Our reference: DCO/2024/00005

MMO scoping consultation response on the application by National Grid Ventures Limited (the “Applicant”) for an Order granting Development Consent for the LionLink Multi-Purpose Interconnector (the “Proposed Development”).

Scoping consultation response

Title: LionLink Multi-Purpose Interconnector

Drawing Title  
Figure 20.2 Fish species spawning and nursery grounds within the study area  
Scale at A3  
1:1700000

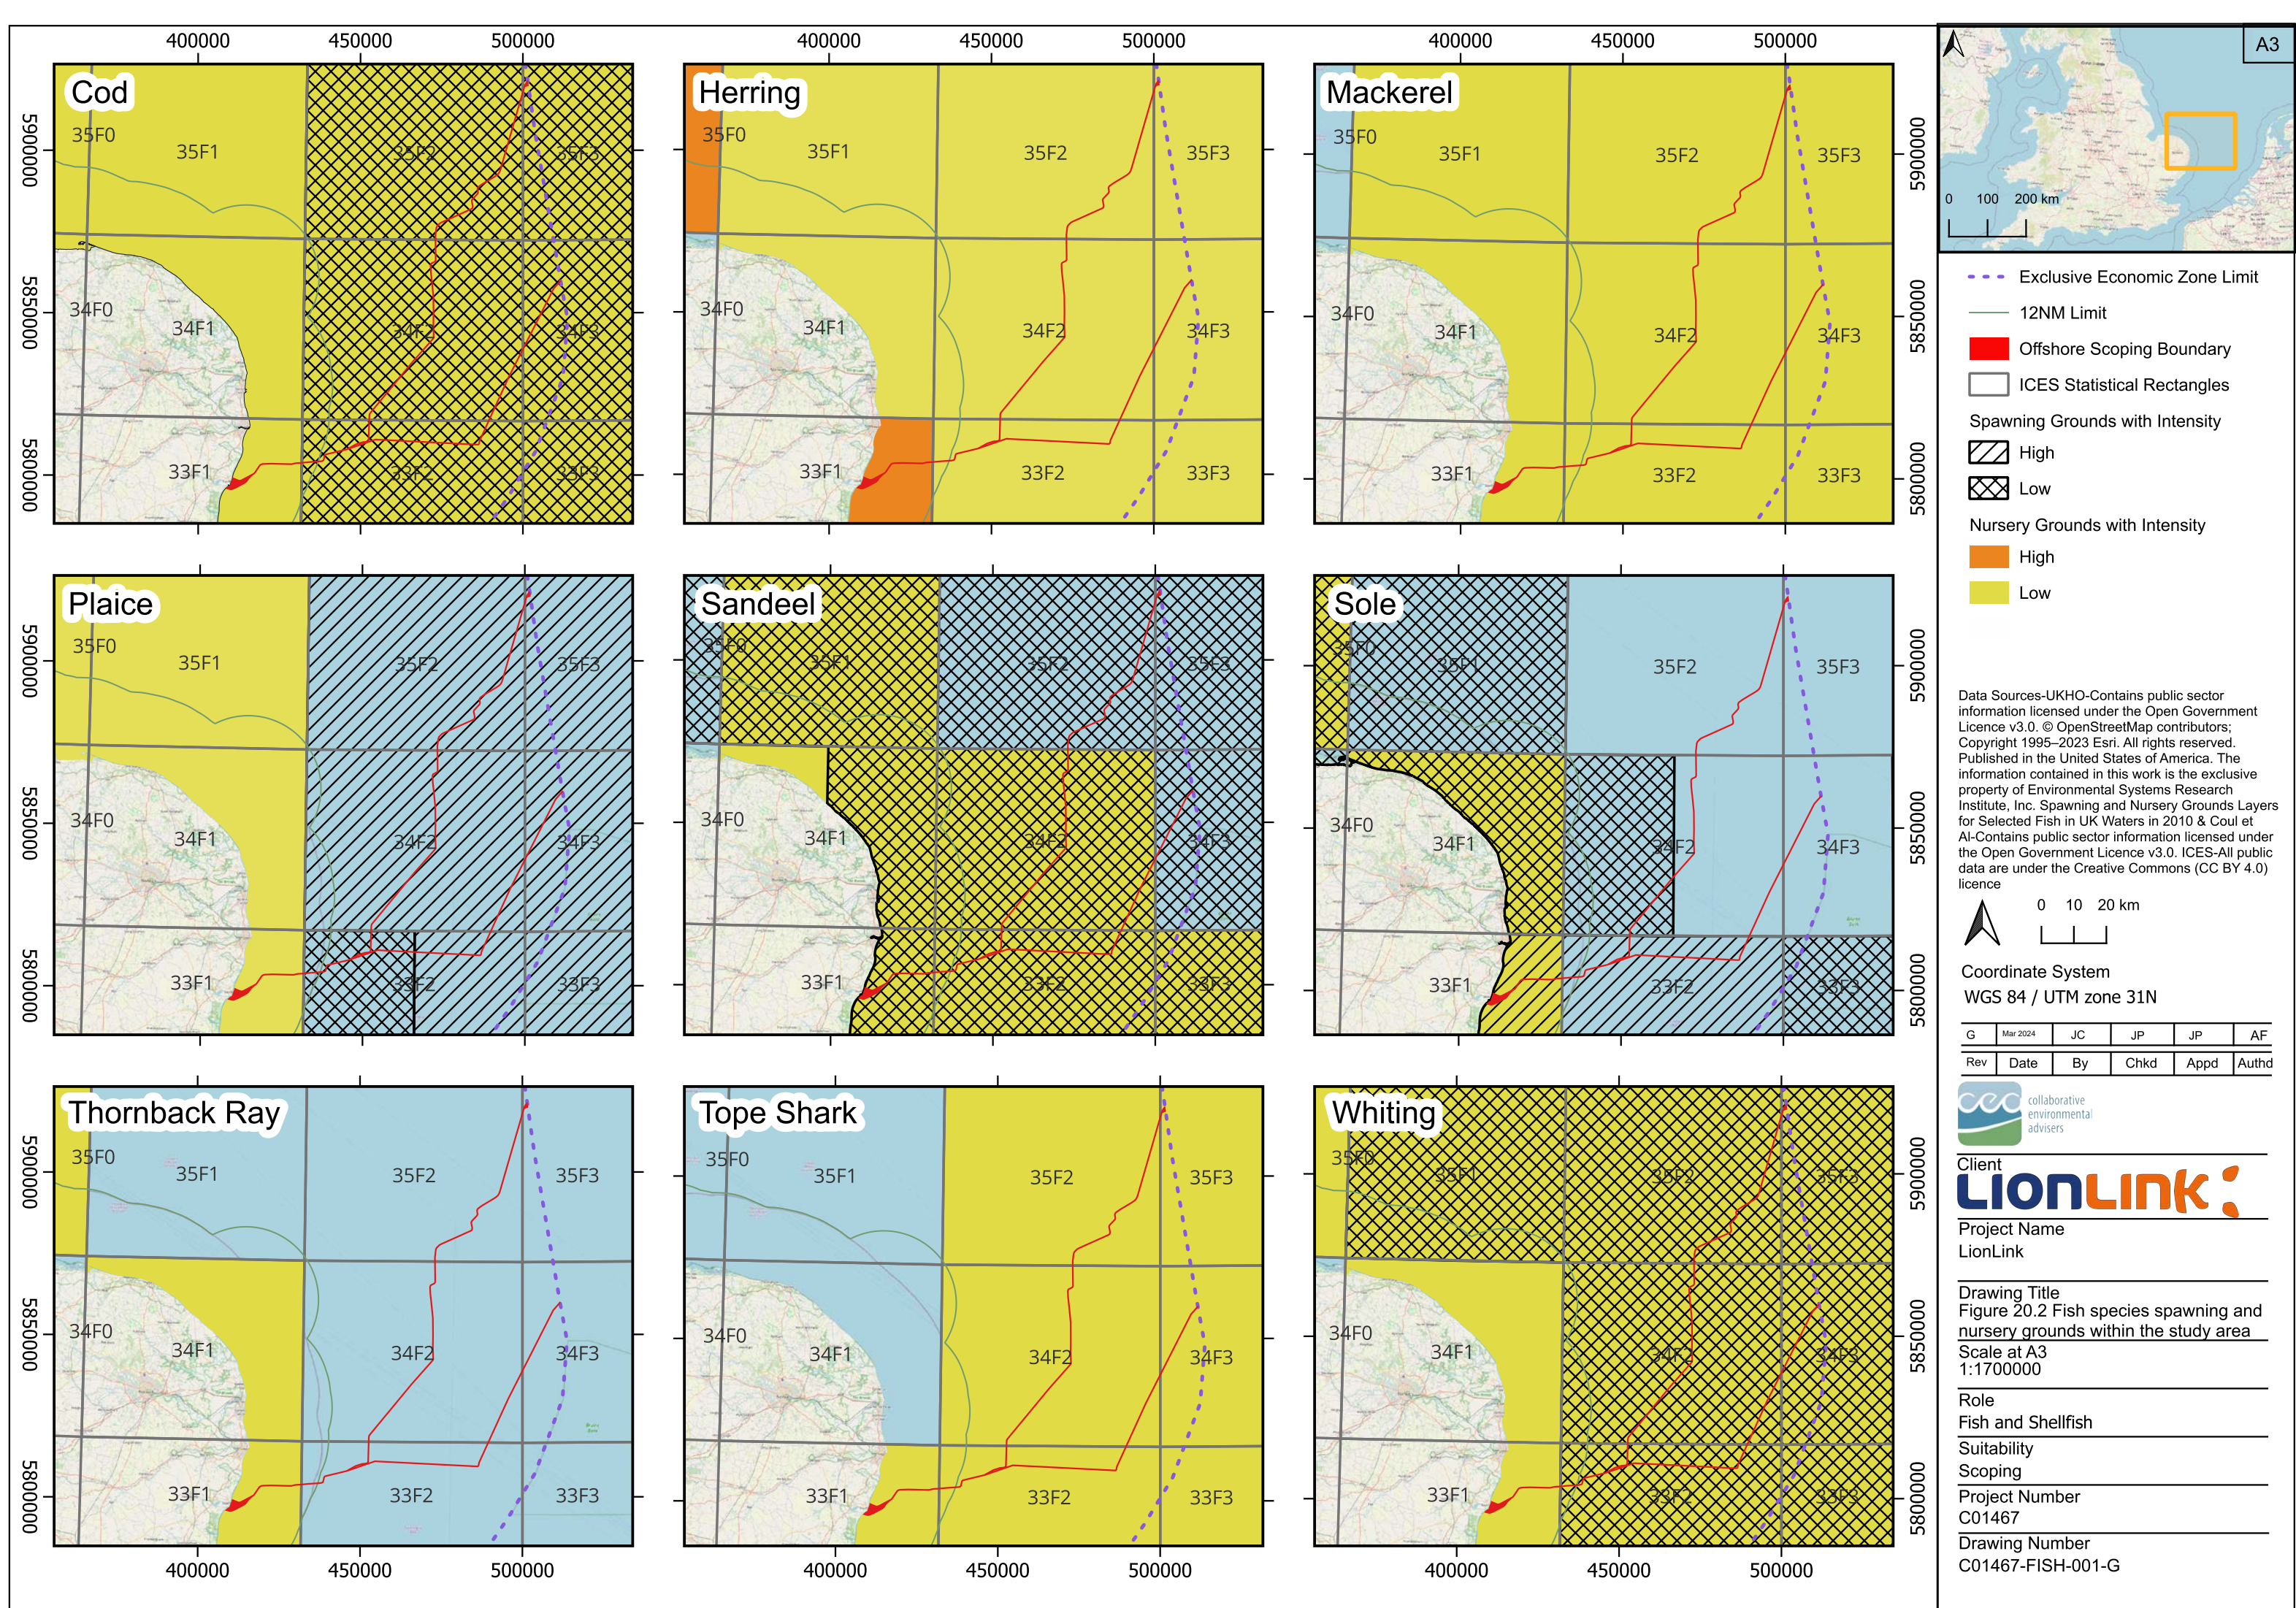
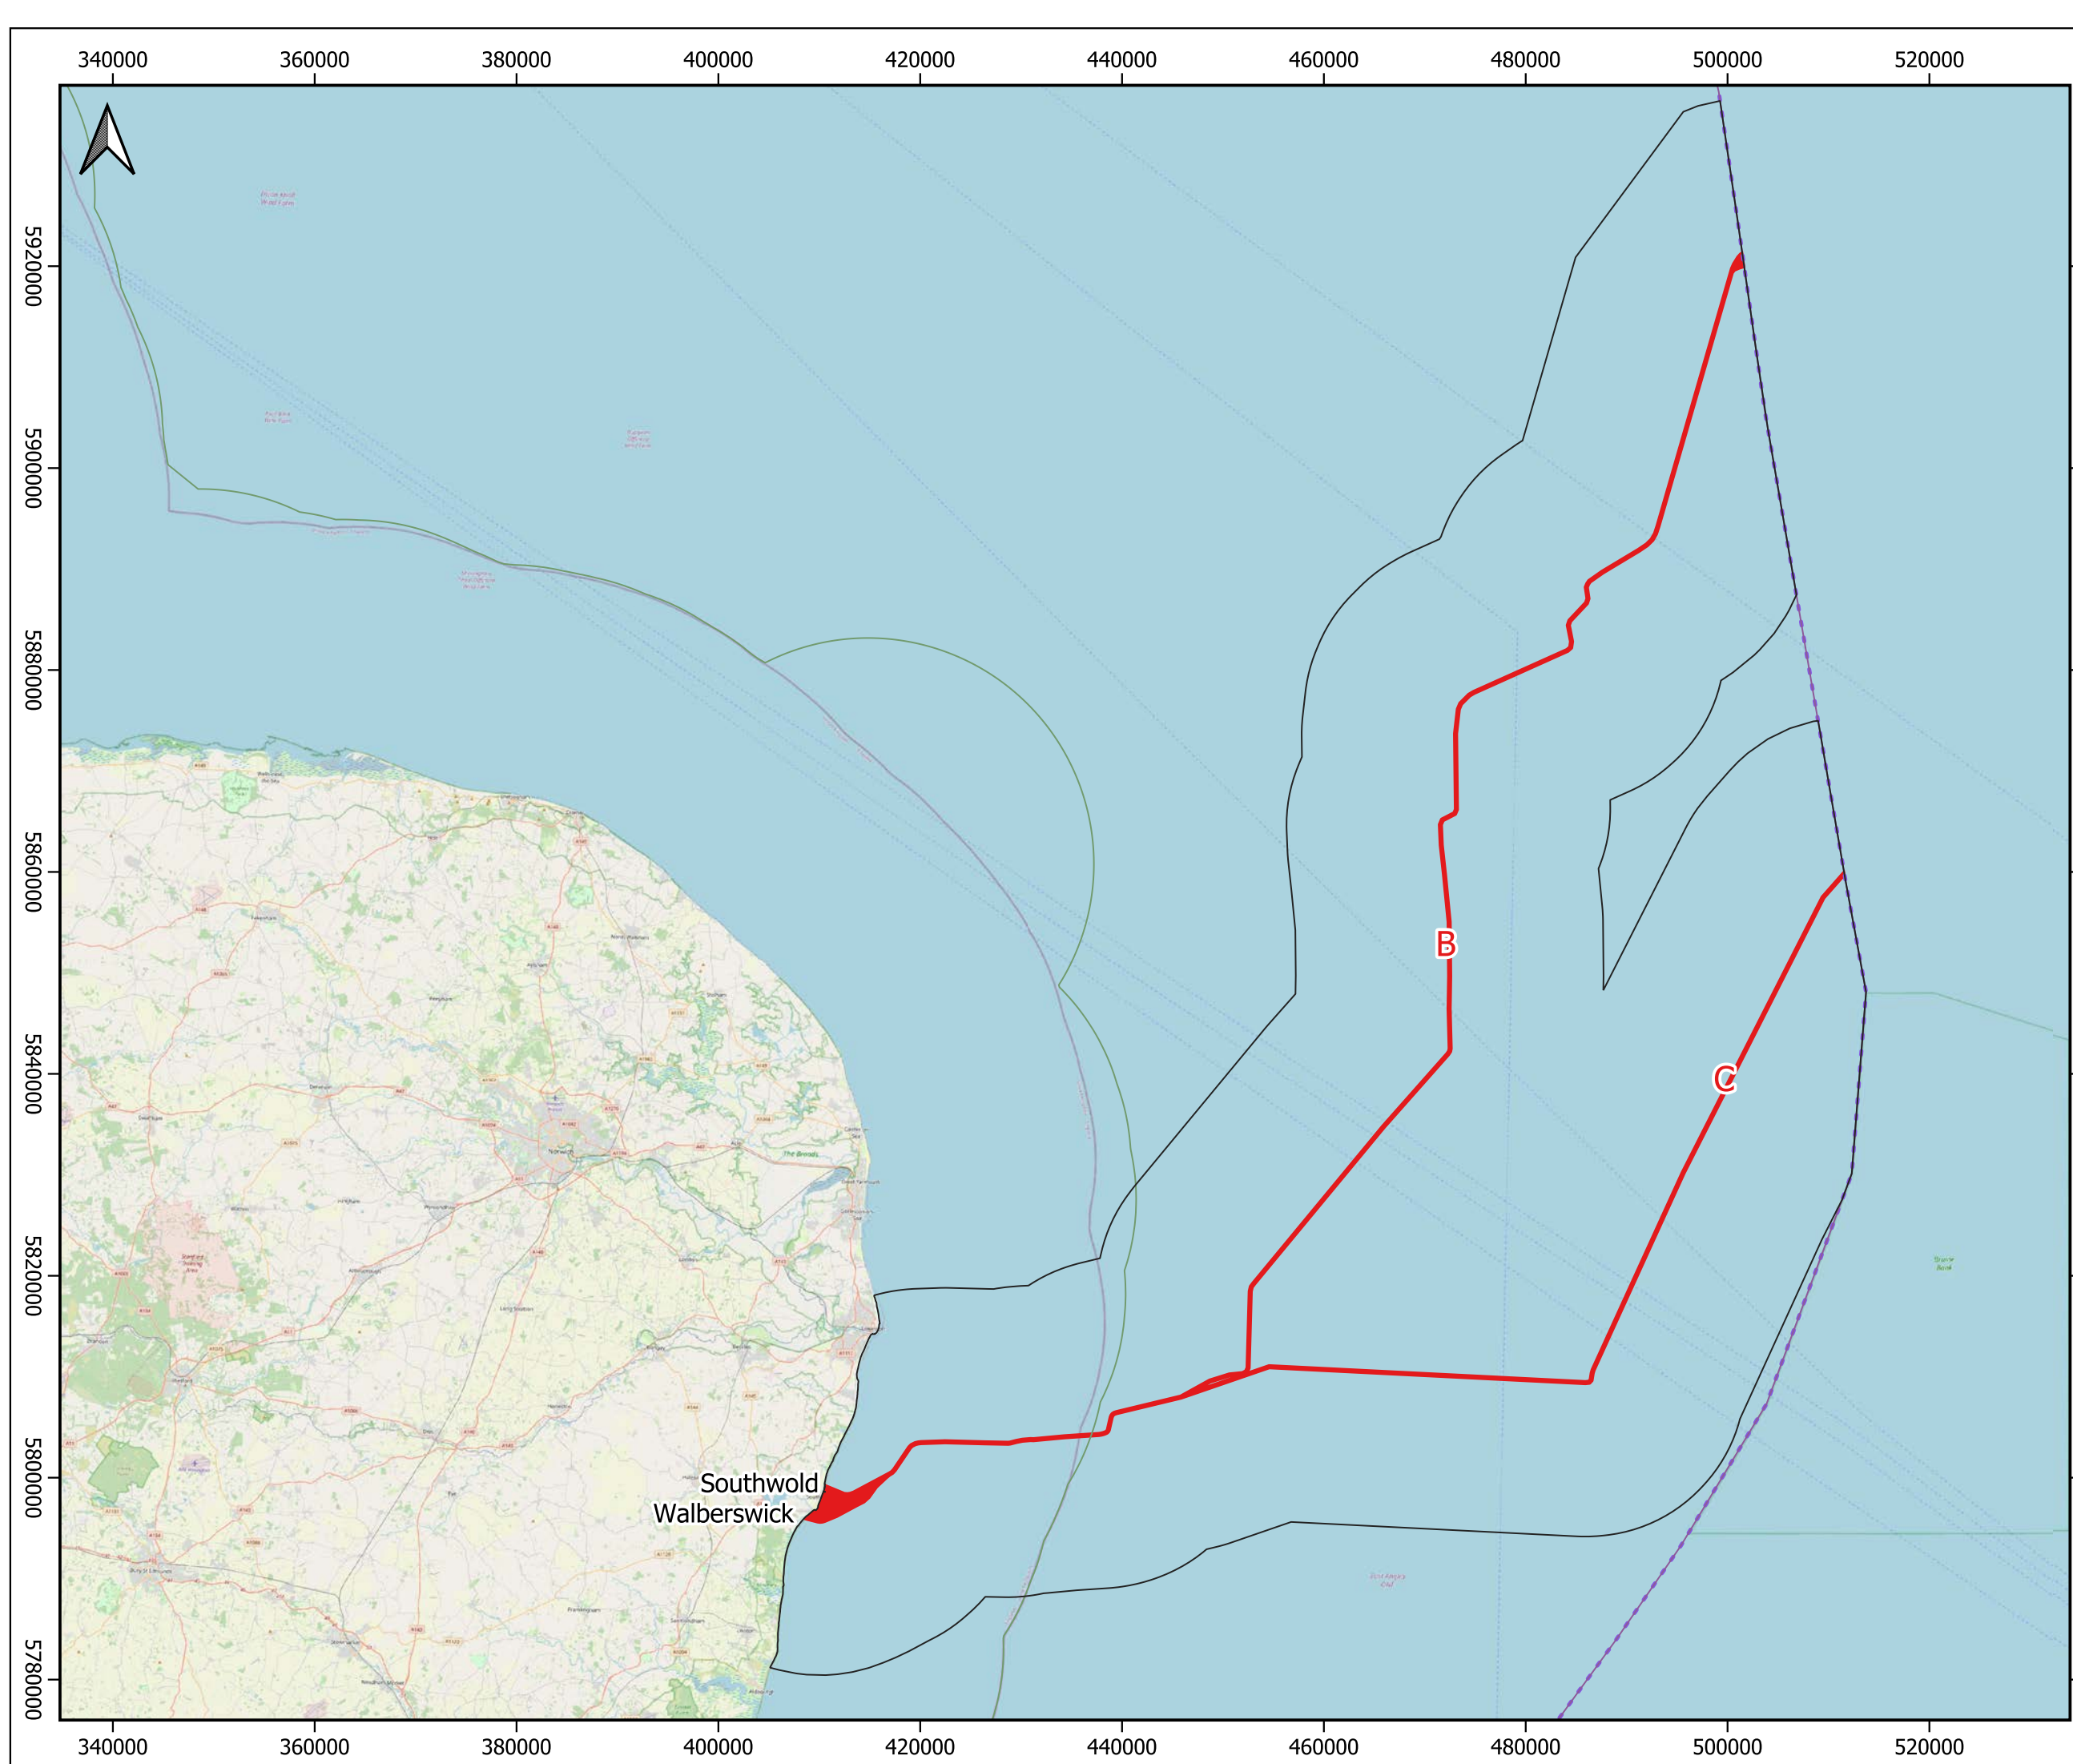
- 3.3.3 The report has presented maps showing spawning and nursery grounds it is stated these are informed by Coull et al., (1998) and Ellis et al., (2012). However, spawning grounds in these figures do not match up with those presented in these studies. For example, no herring spawning grounds are presented, only high and low intensity nursery grounds. In addition, high intensity nursery grounds are shown for cod and whiting across the majority of the study area, whereas Ellis et al., (2012) marks these as only low intensity spawning grounds. The spawning grounds for plaice and sole also show discrepancies between Ellis et al., (2012) and those presented in Figure 20-1. The maps presented should be reviewed and the necessary corrections made.
